ENG-CDR20005-R2-FDR-Redlines.pdf Markup Summary

Subject: EPC ENG Review
Page Index: 1
Date: 10/30/2020 2:12:20 PM
Author: dsdrice
Color: ■
Layer:
Space:
Page Label: 1

STERLING RANCH EXISTING DRAINAGE MAP

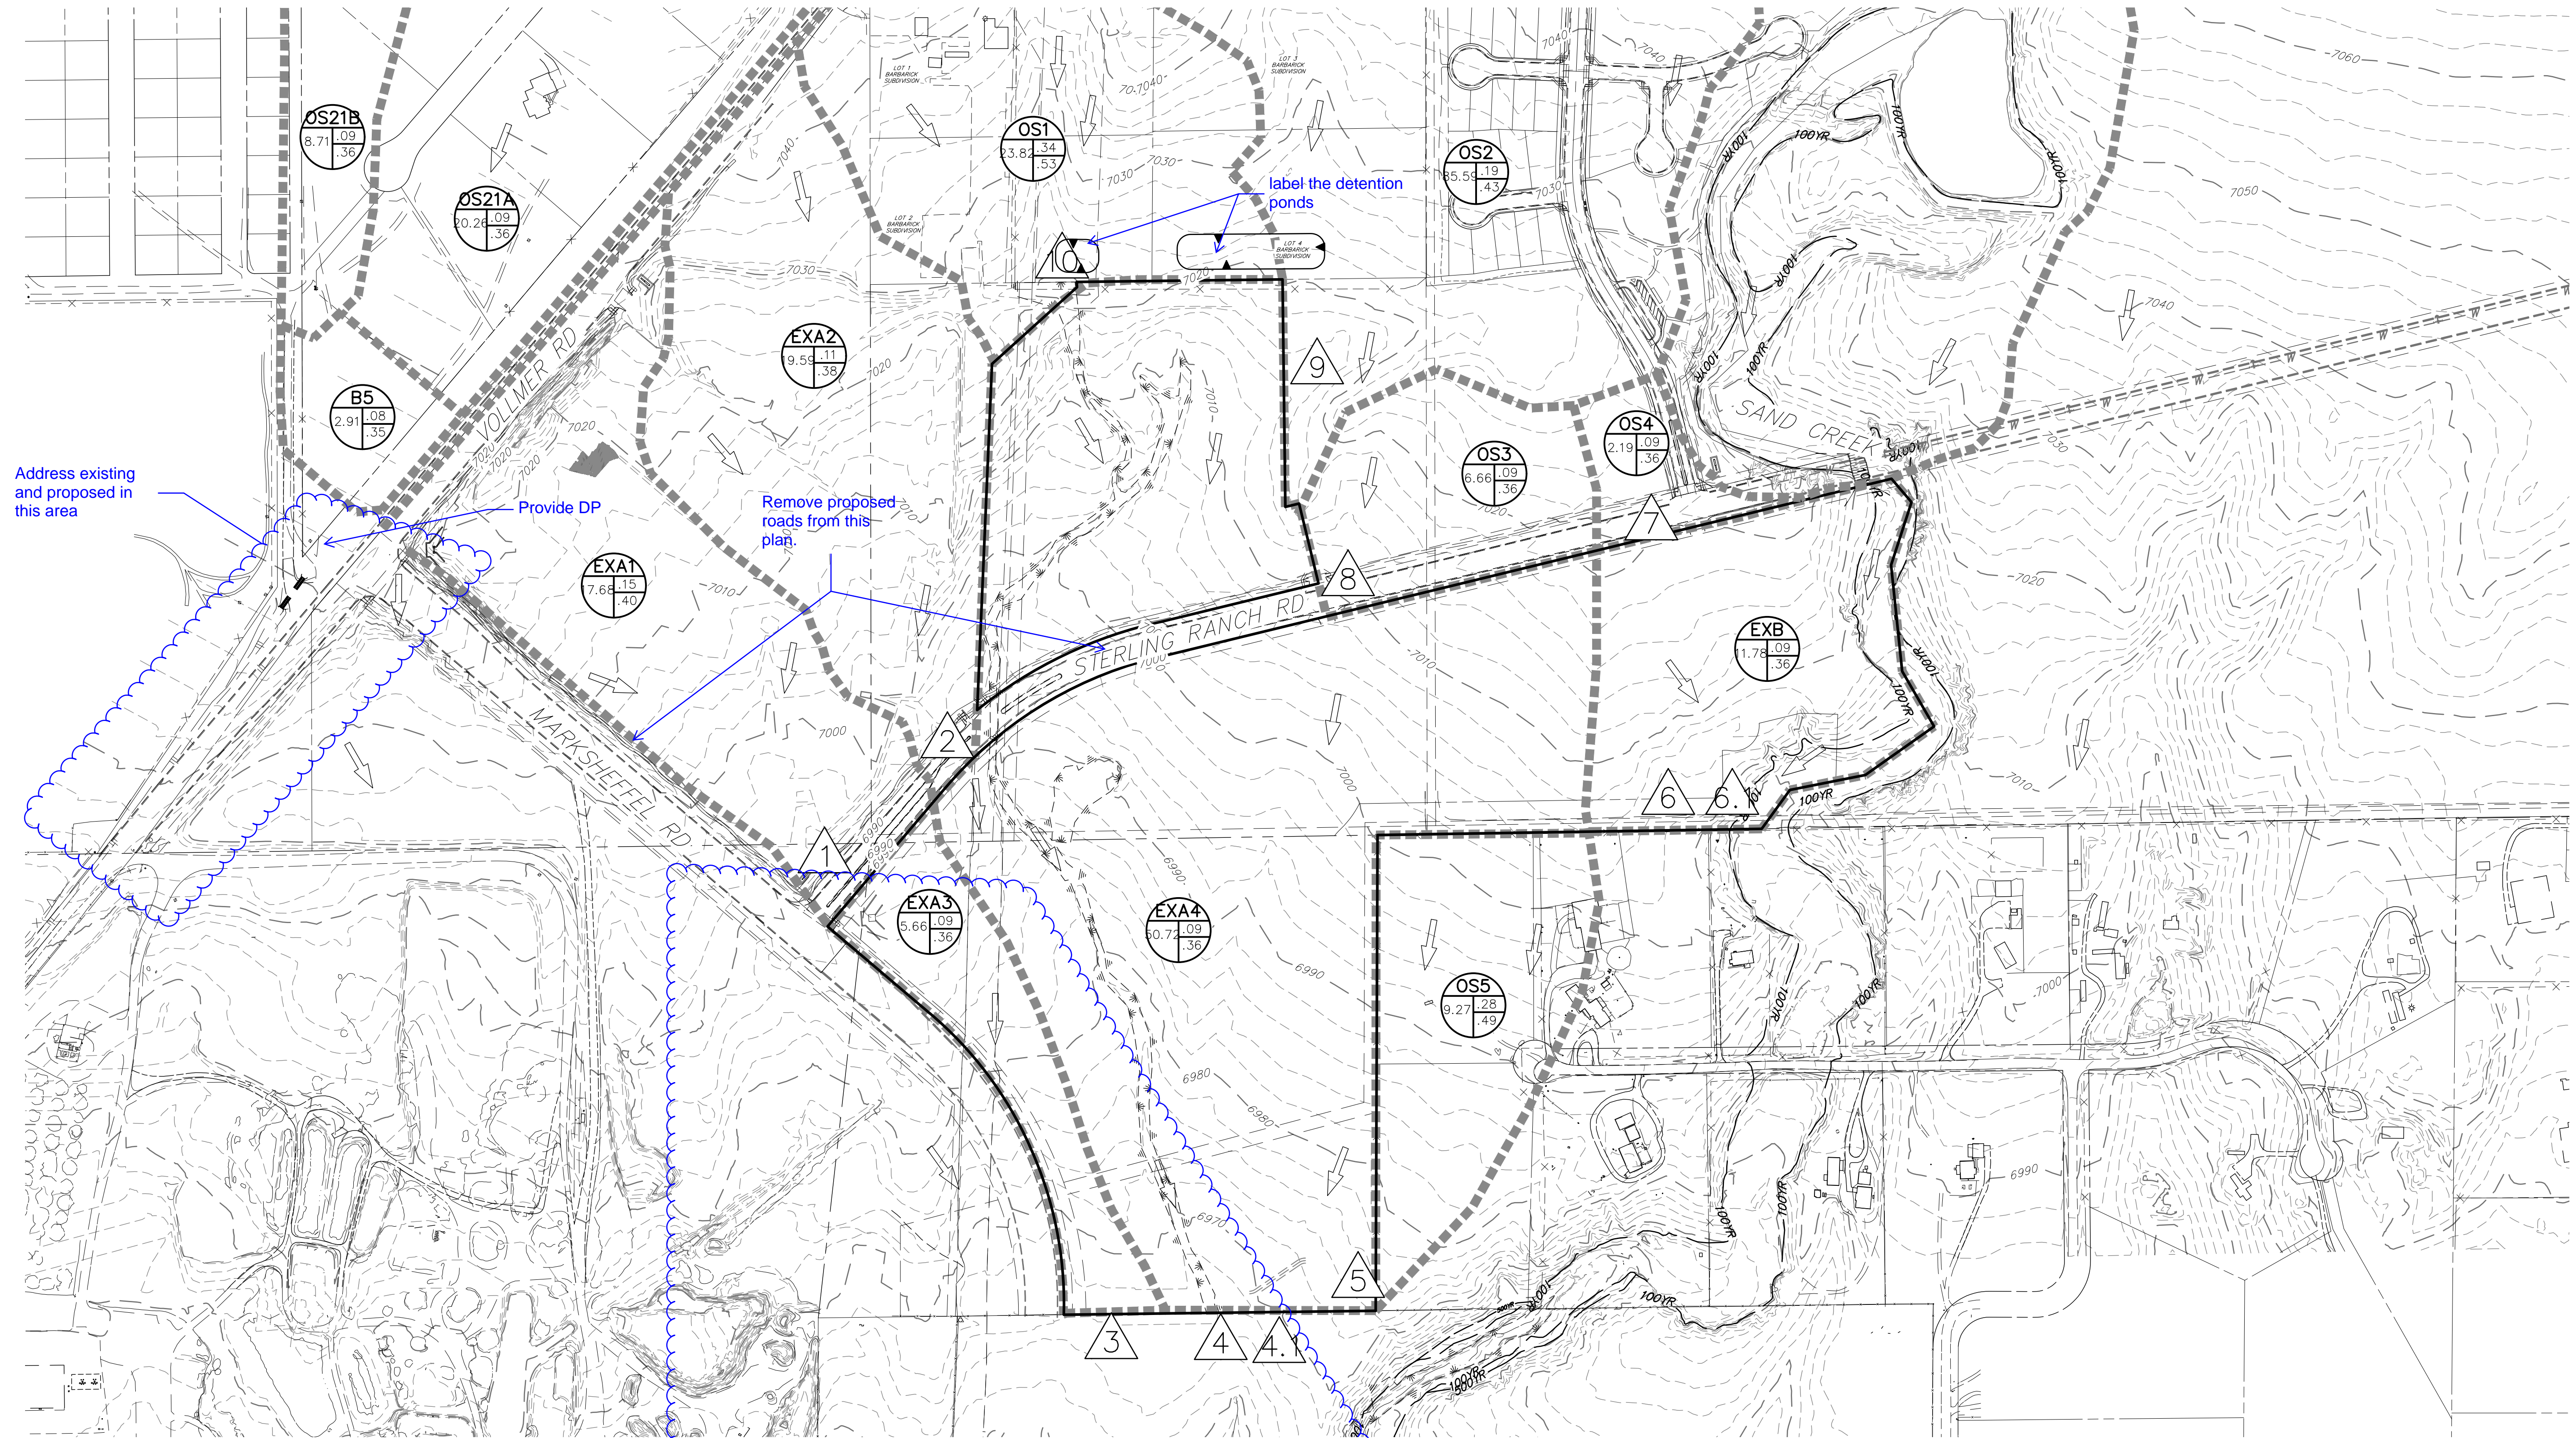
Remove proposed roads from this plan.

label the detention ponds

Show basin lines and tributary stream flowlines in this area.

Show where Sand Creek and tributary combine and SCDBPS design points south of those provided.

Provide DP

Address existing and proposed in this area

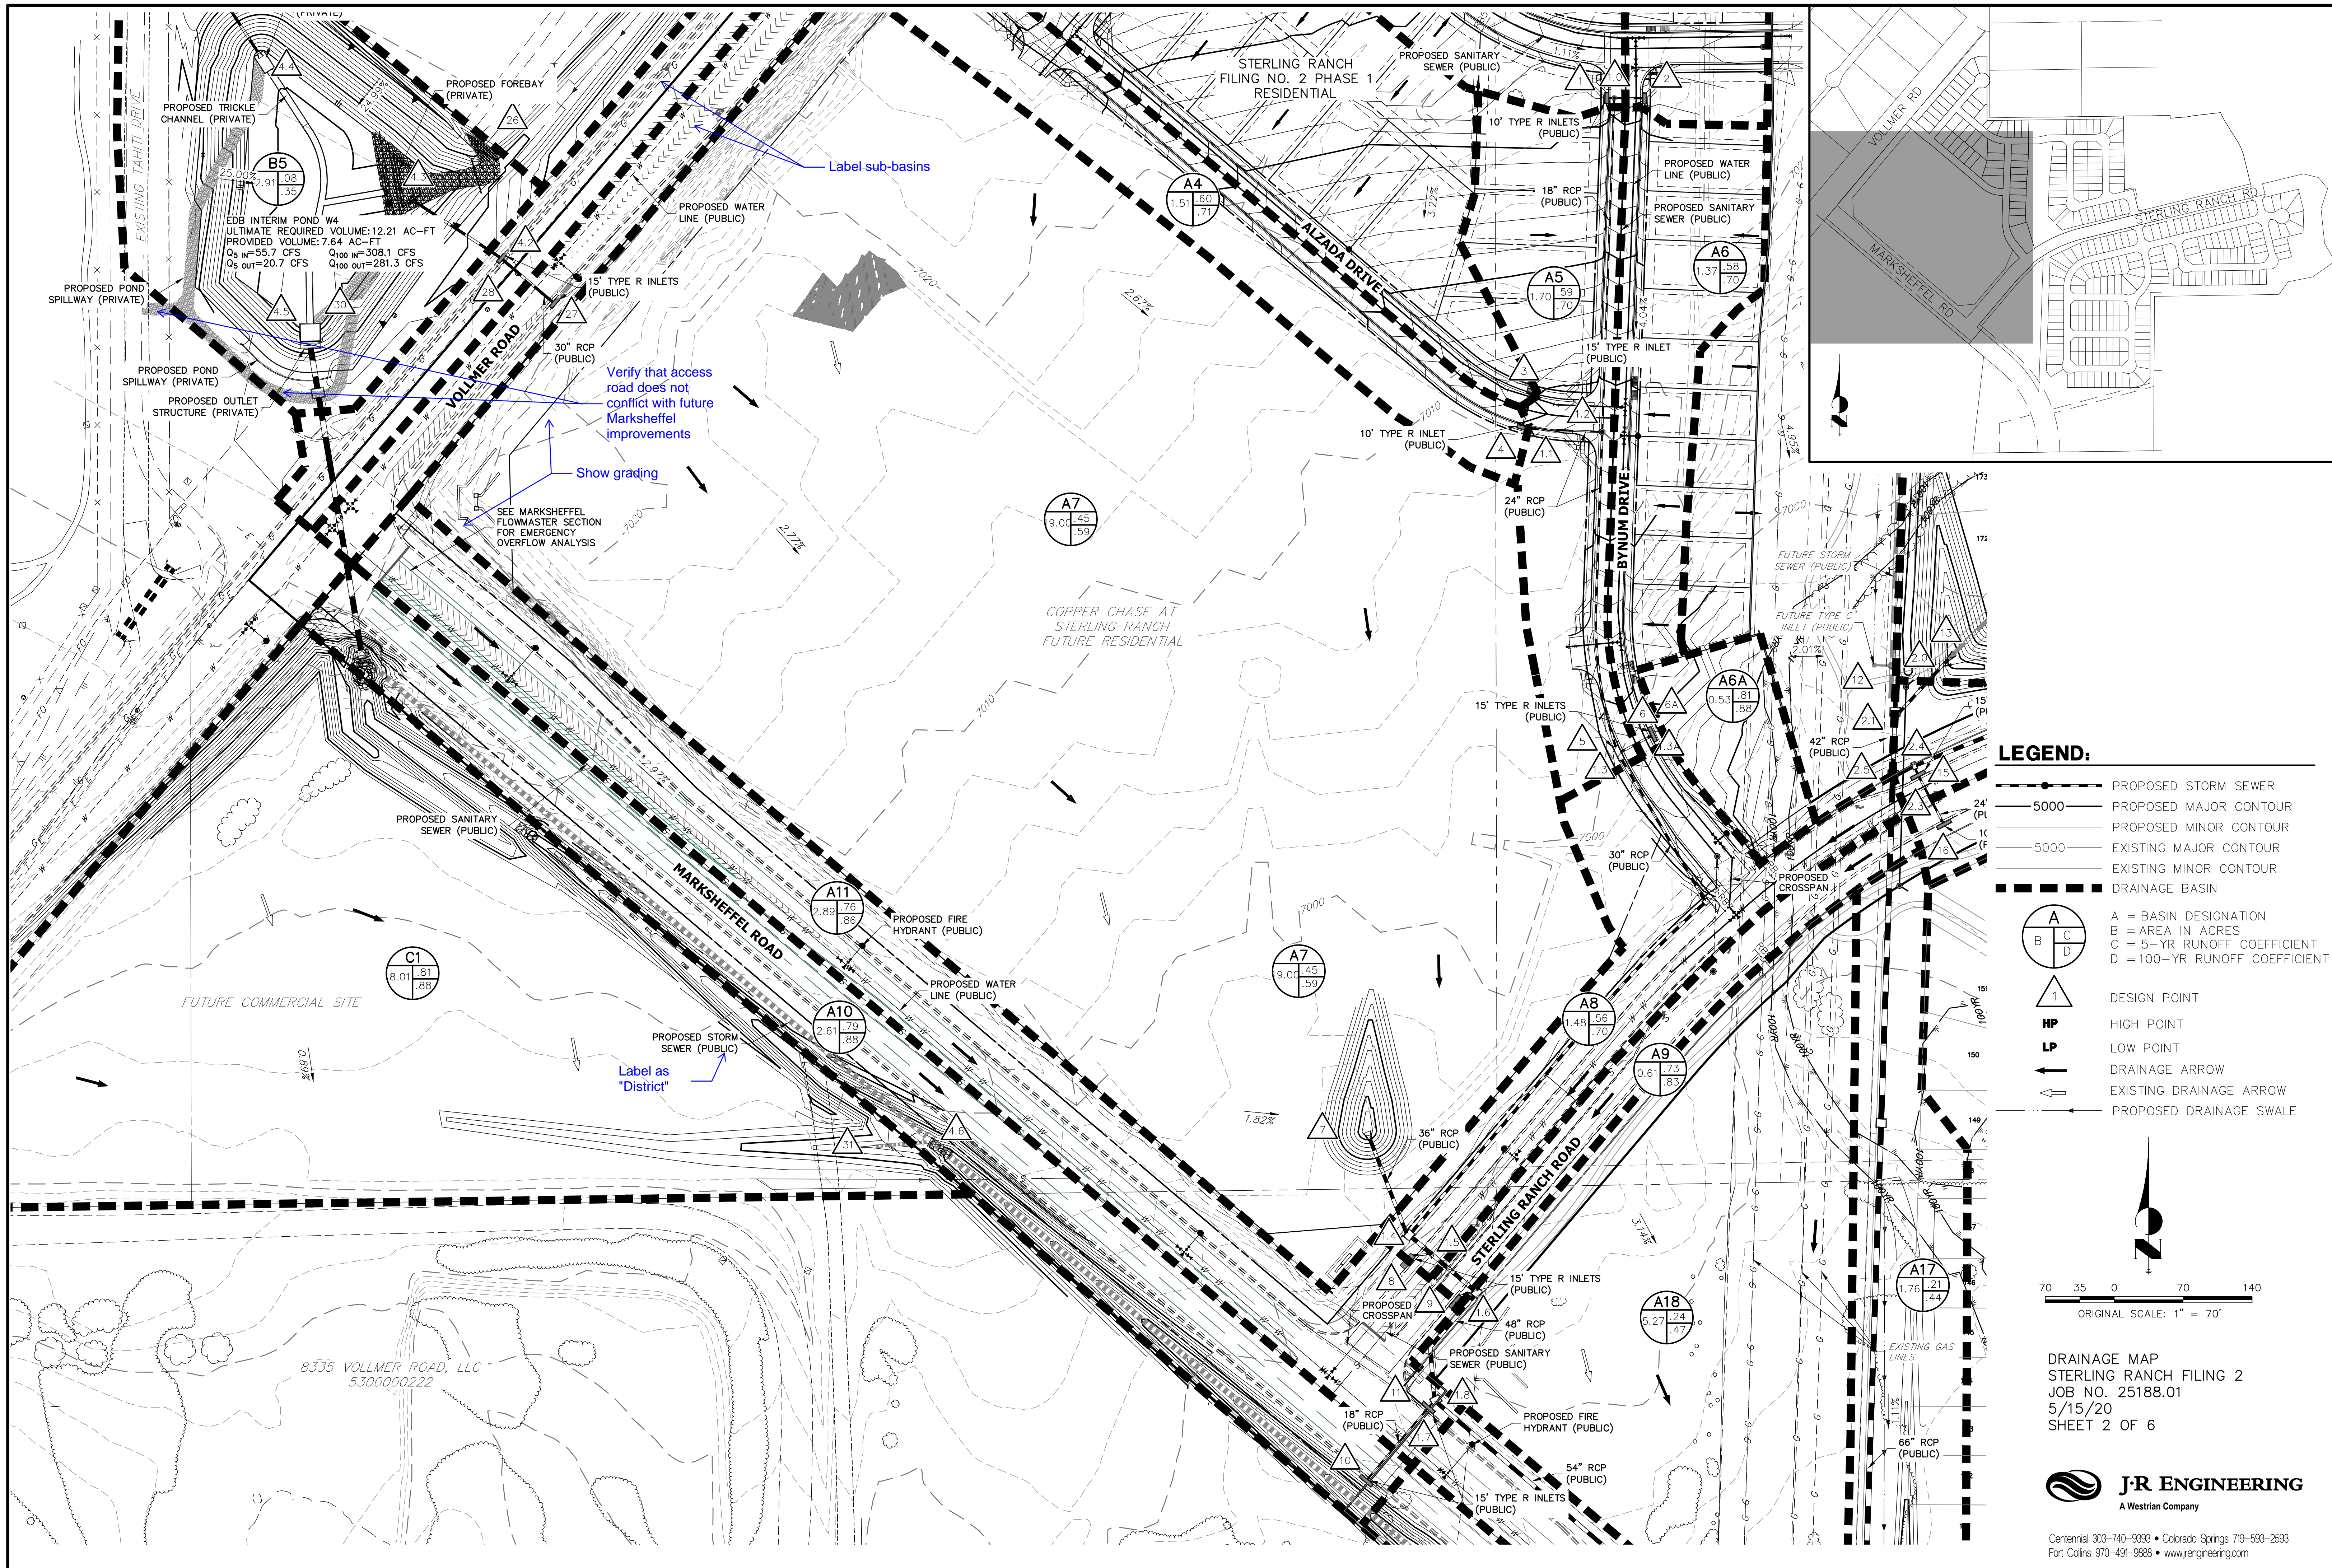
SCS/MDDP/DBPS calculation?

Emergency overflow path?

Provide an emergency conditions analysis addressing how flows from upstream basins are conveyed from here to the southeast.

Obtain City approval for maintenance access roads from Marksheffel Road.

DRAINAGE MAP
 STERLING RANCH FILING 2
 JOB NO. 25188.01
 5/15/20
 SHEET 3 OF 6

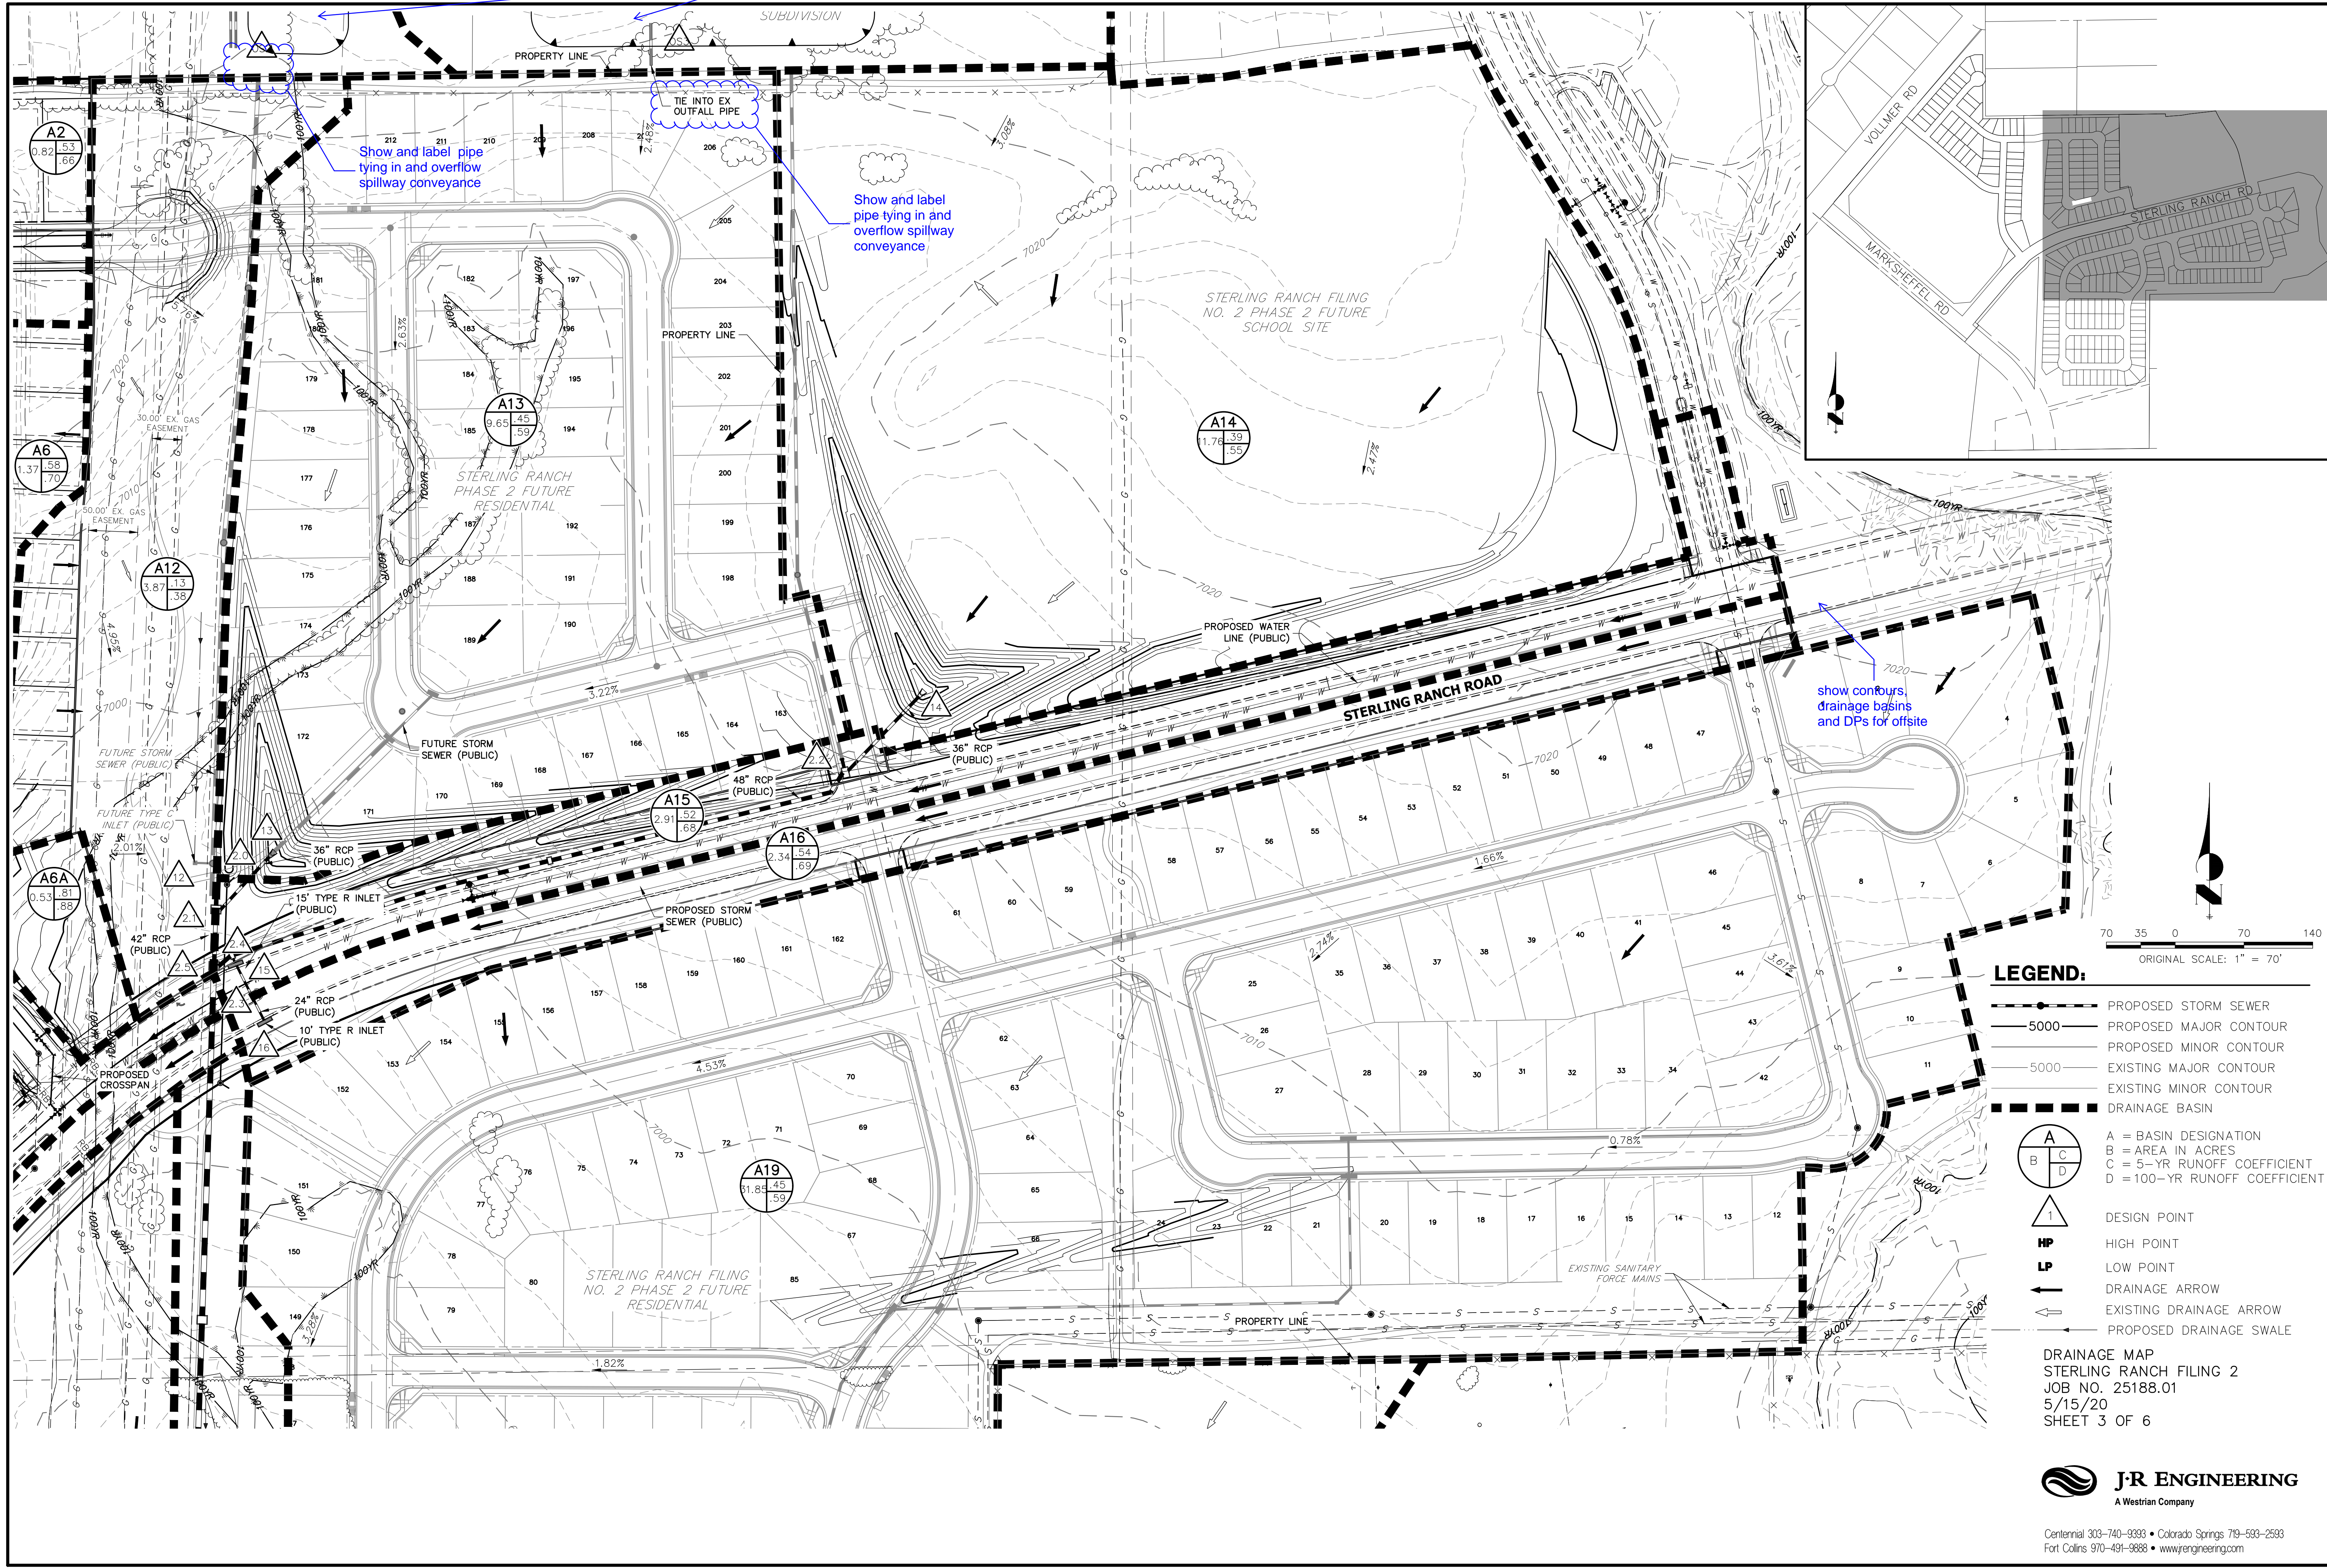
Label sub-basins

Label as "District"

Show grading

Verify that access road does not conflict with future Marksheffel improvements
